**CIRCLE K AT HIGHWAY 24 & MERIDIAN ROAD
SITE DEVELOPMENT PLAN**
EL PASO COUNTY, COLORADO
SEPTEMBER 2022

**SHEET 1 OF 2
TS01**

SHEET 2 OF 2
SP01

Site Plan Drawing_V2 redlines.pdf Markup Summary

## SITE DEVELOPMENT PLAN

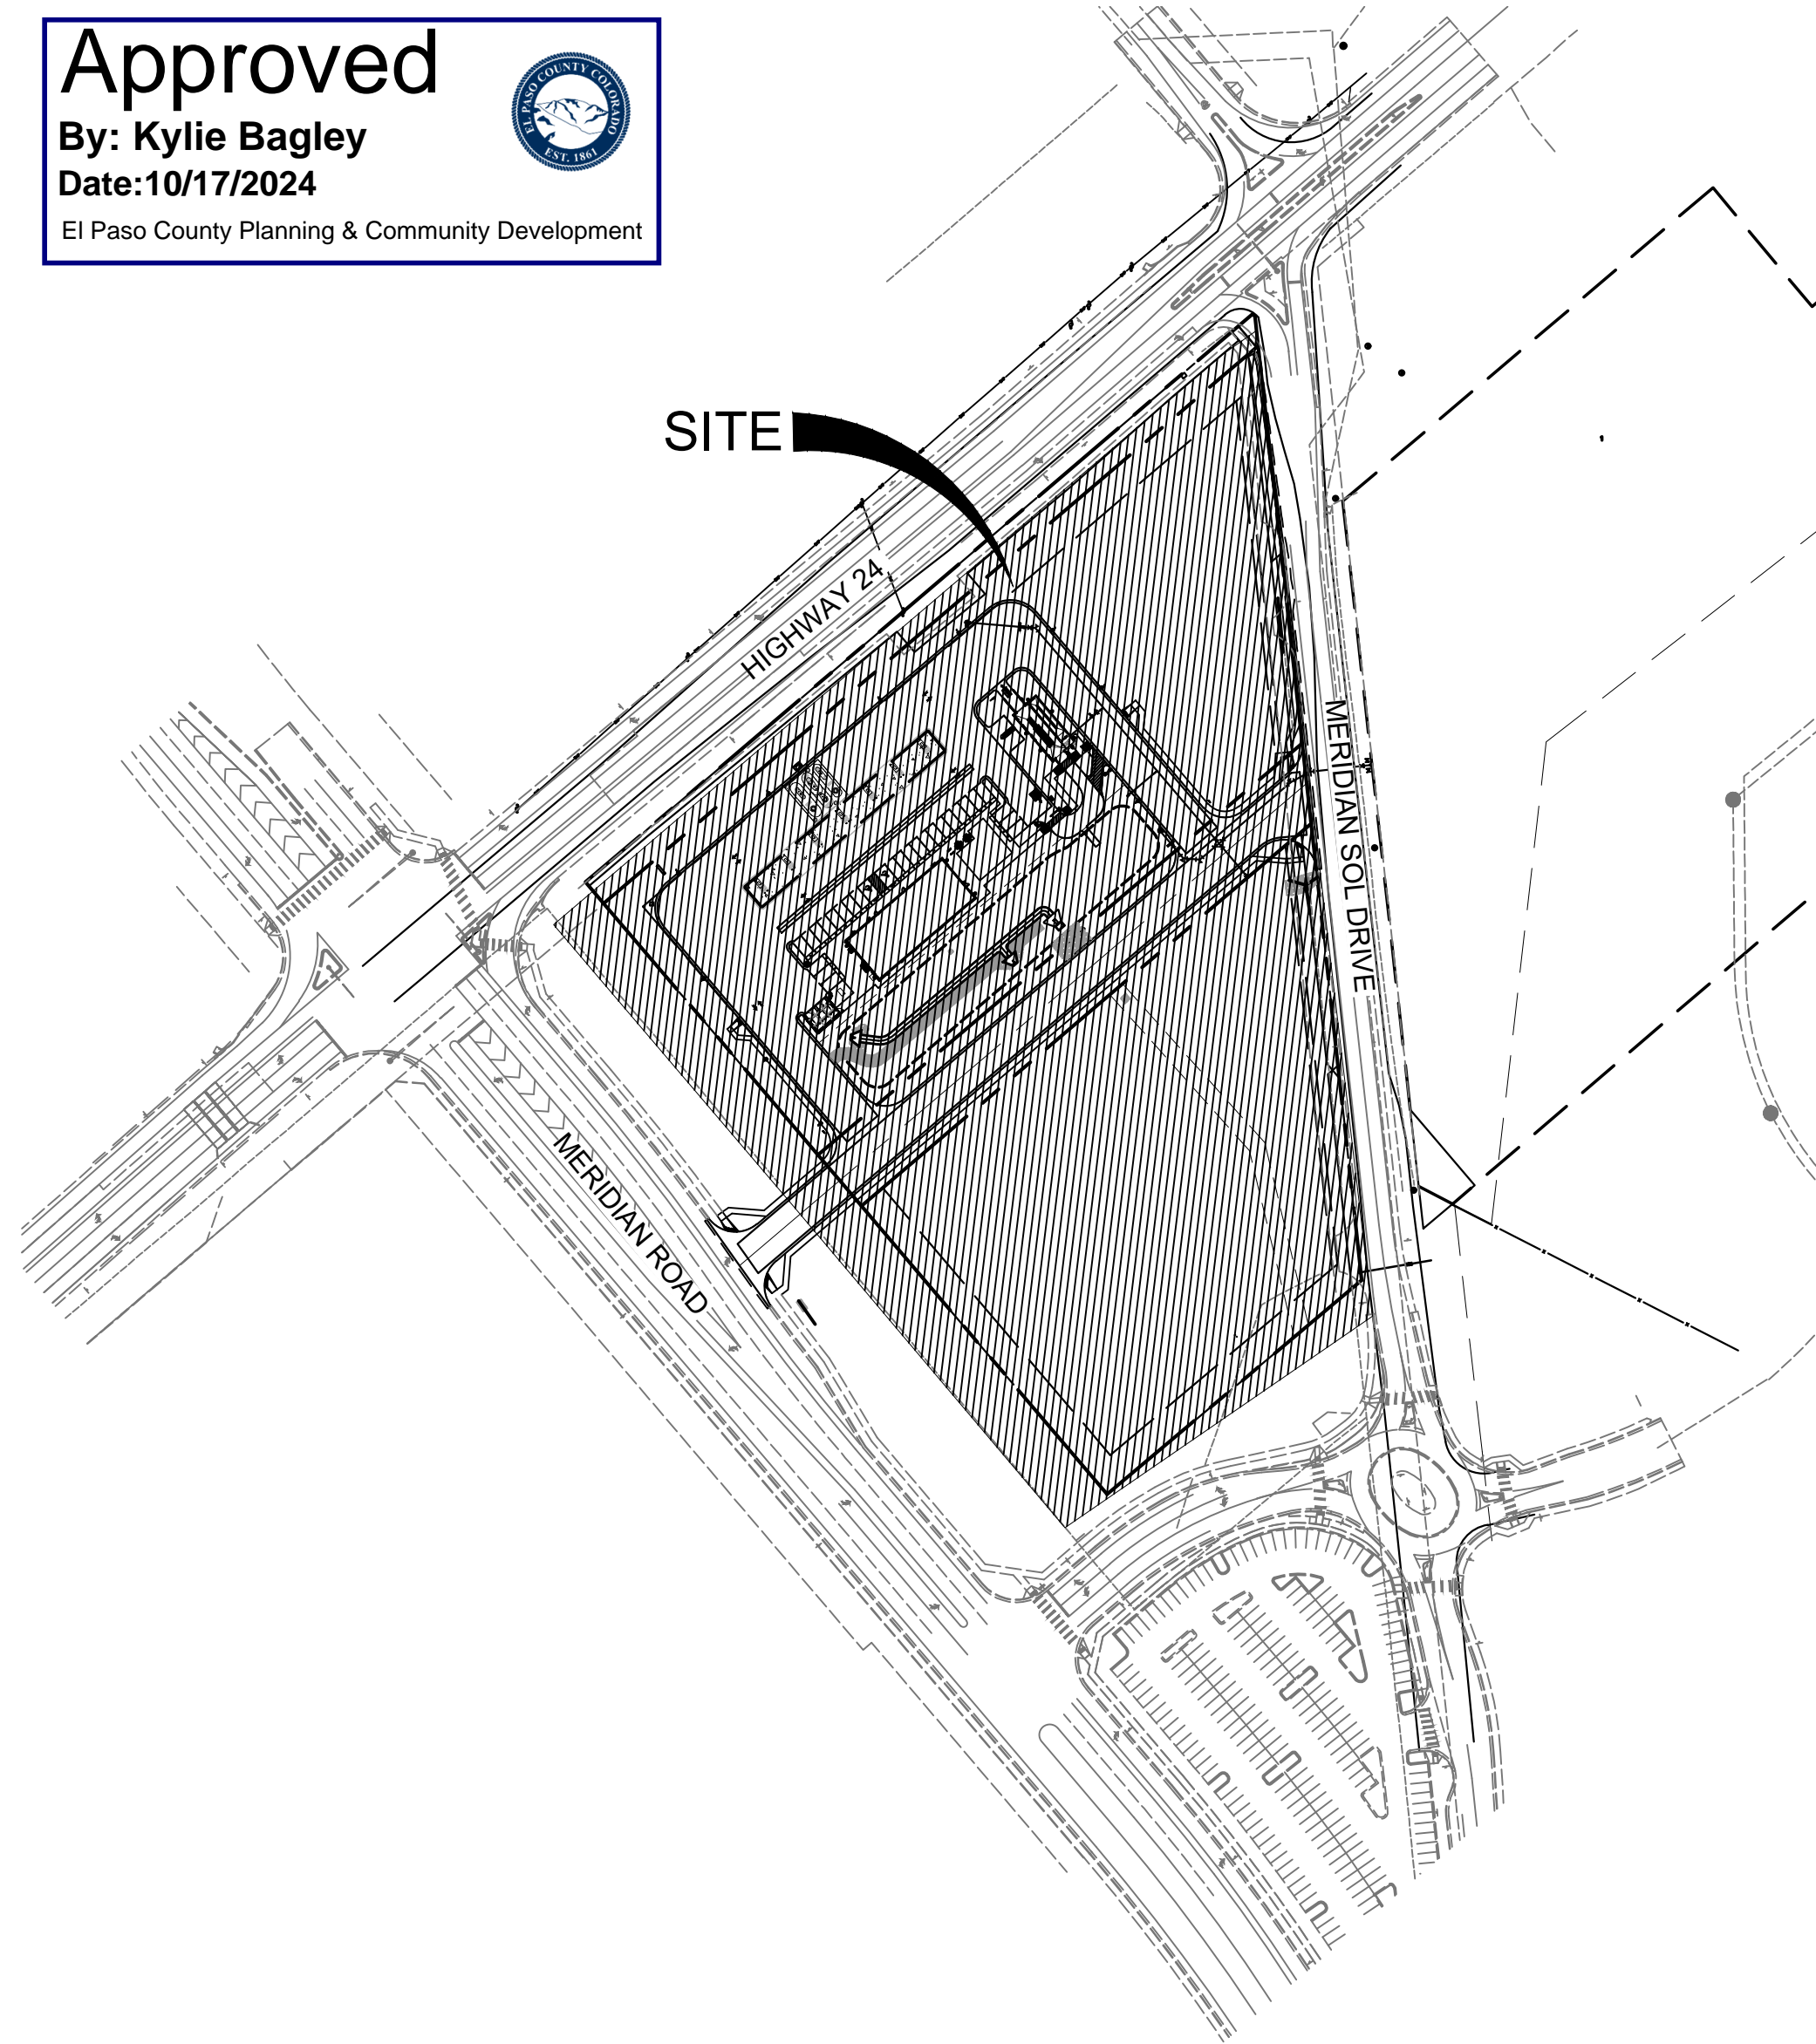
Provide all parcel #'s associated with the project

Please confirm property size

CS or CC? Please clarify

Missing, please add legal description

SHEET 2 OF 2  
 SP01  
 ISSUE DATE: JANUARY 2023

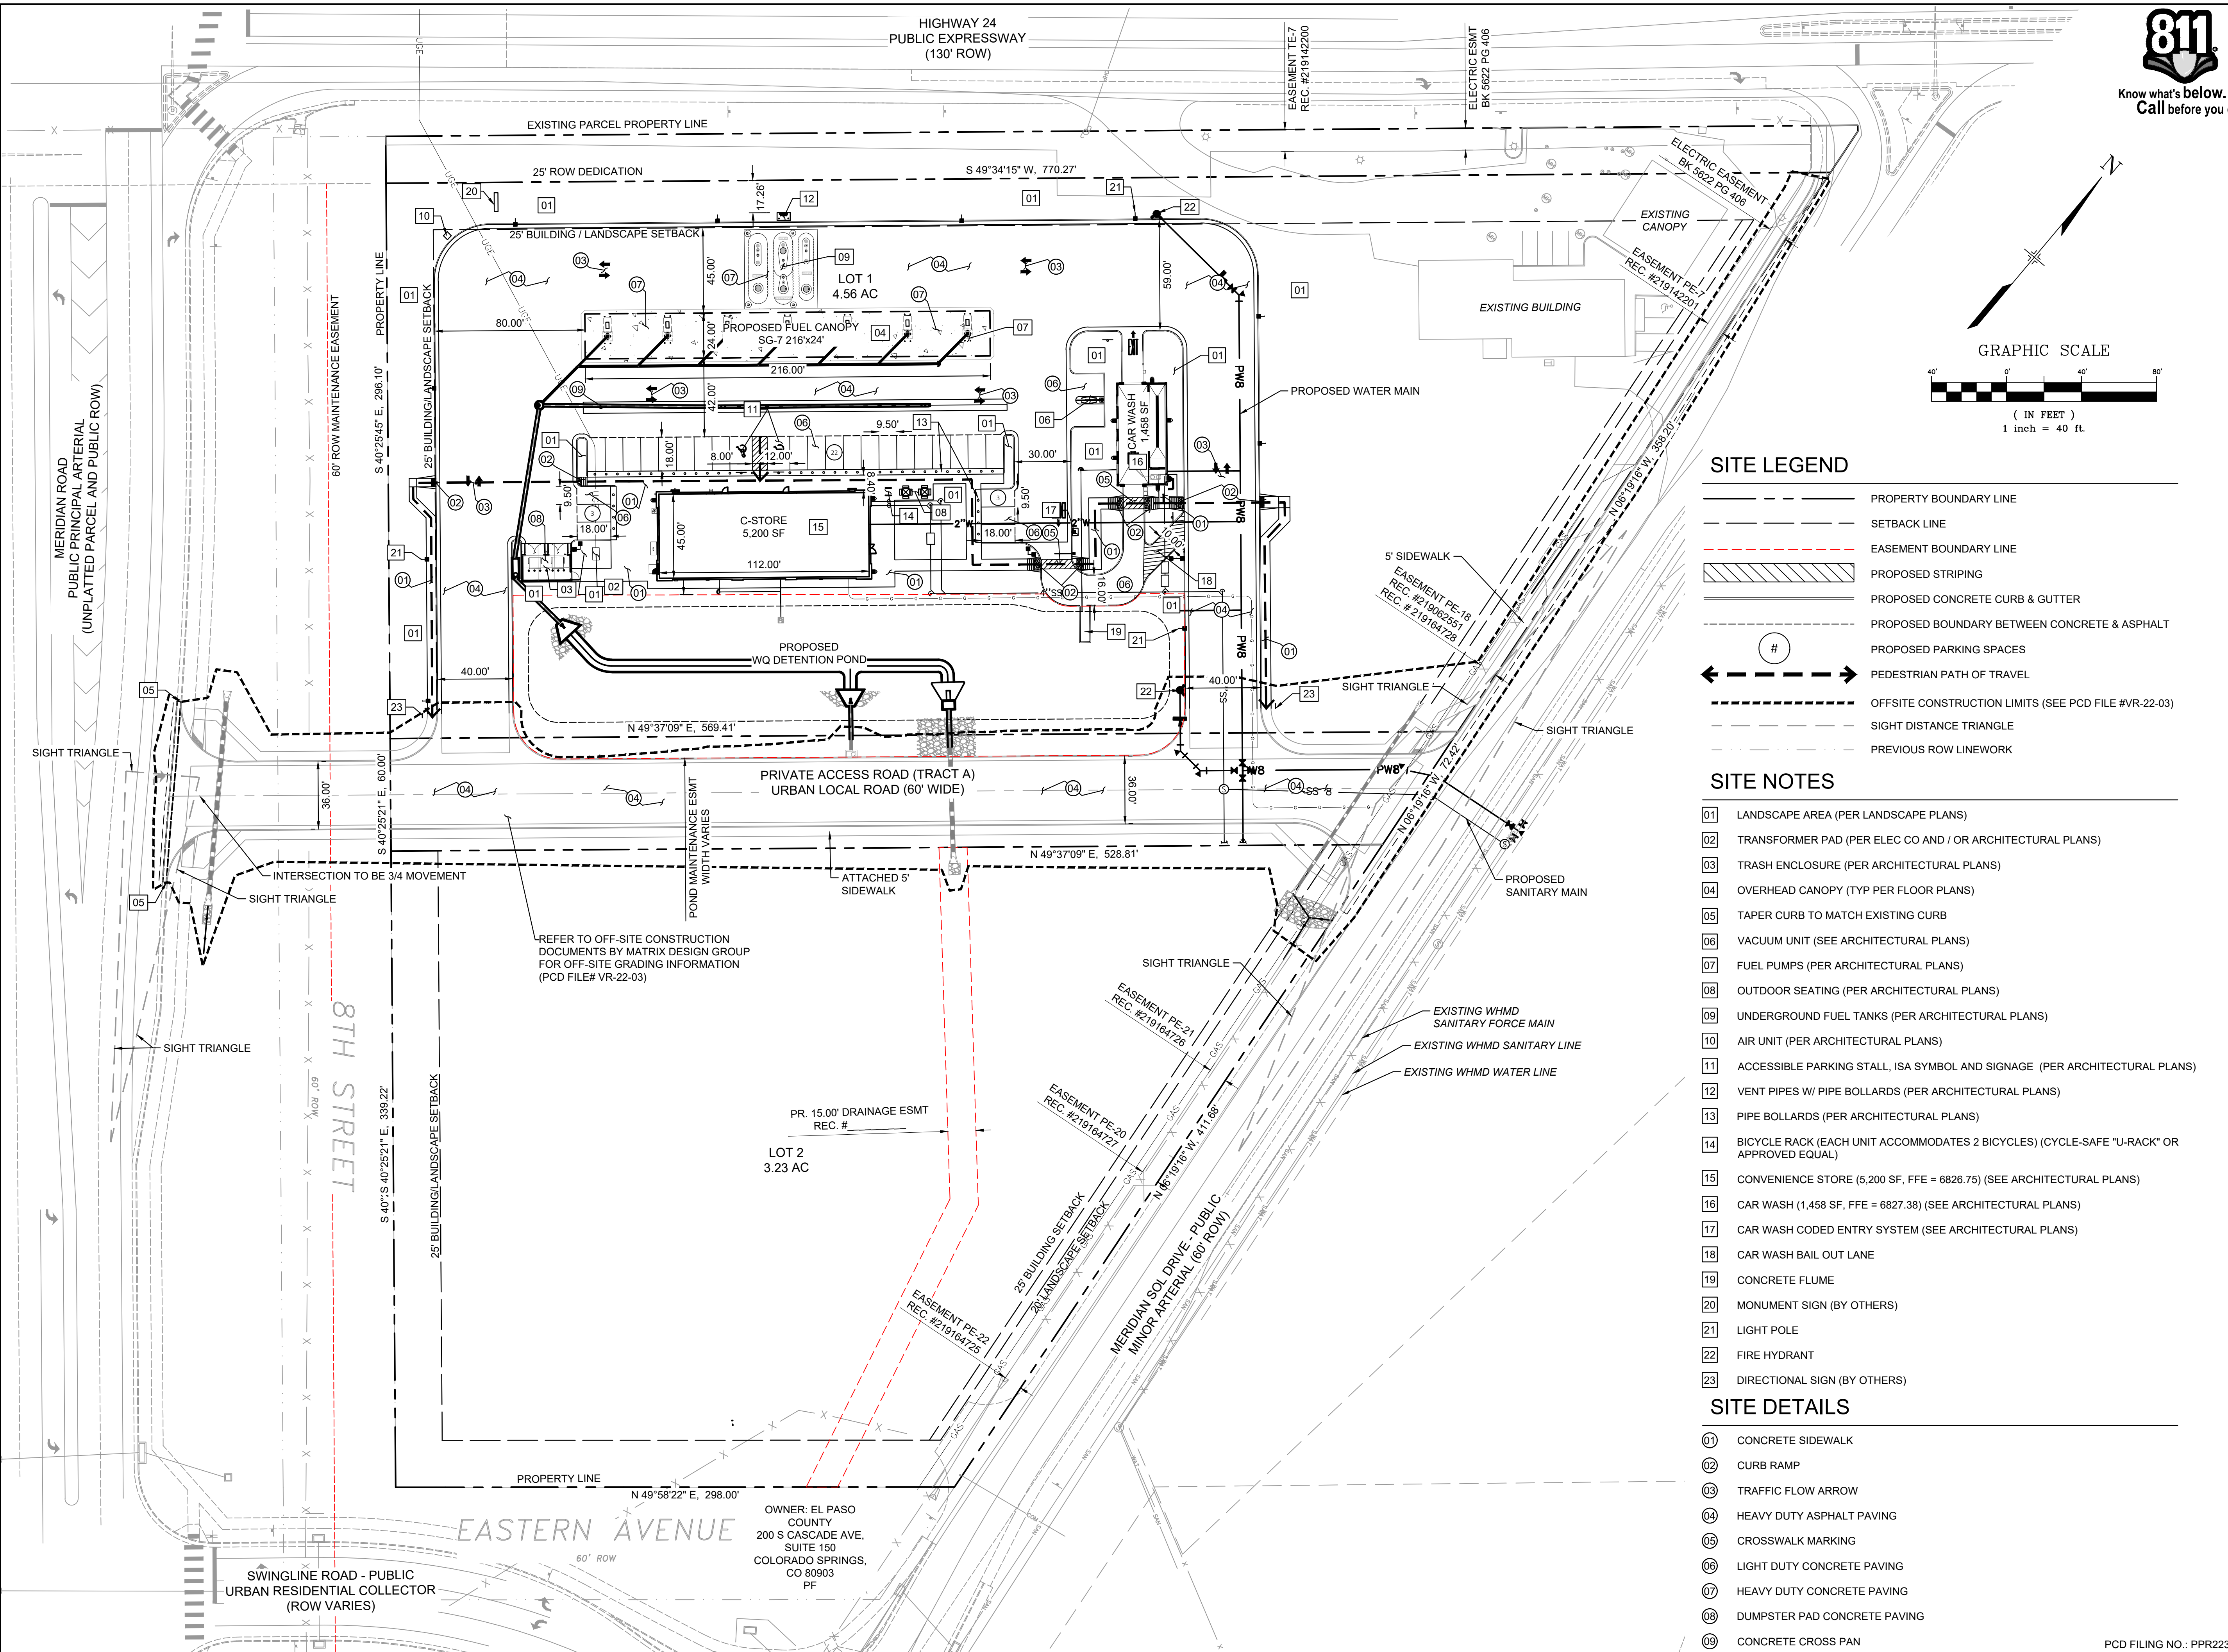
Show sight distance triangles

Show on plans the location of existing and proposed water and wastewater infrastructure, including well and septic locations, if applicable

Location of all no-build areas, floodplain, drainageways and facilities

Sign package indicates 3 directional signs. Show on site plan.

Show accessible pathways

Please show location of all existing and proposed utility lines and associated infrastructure on plan.

Add sidewalk both sides

Add missing sidewalk extensions

Denote sidewalk along Meridian St

Provide a graphical depiction of the screening mechanism.
Show on plans all locations of garbage receptacles.

Add PED ramps

This intersection needs to be at a right angle
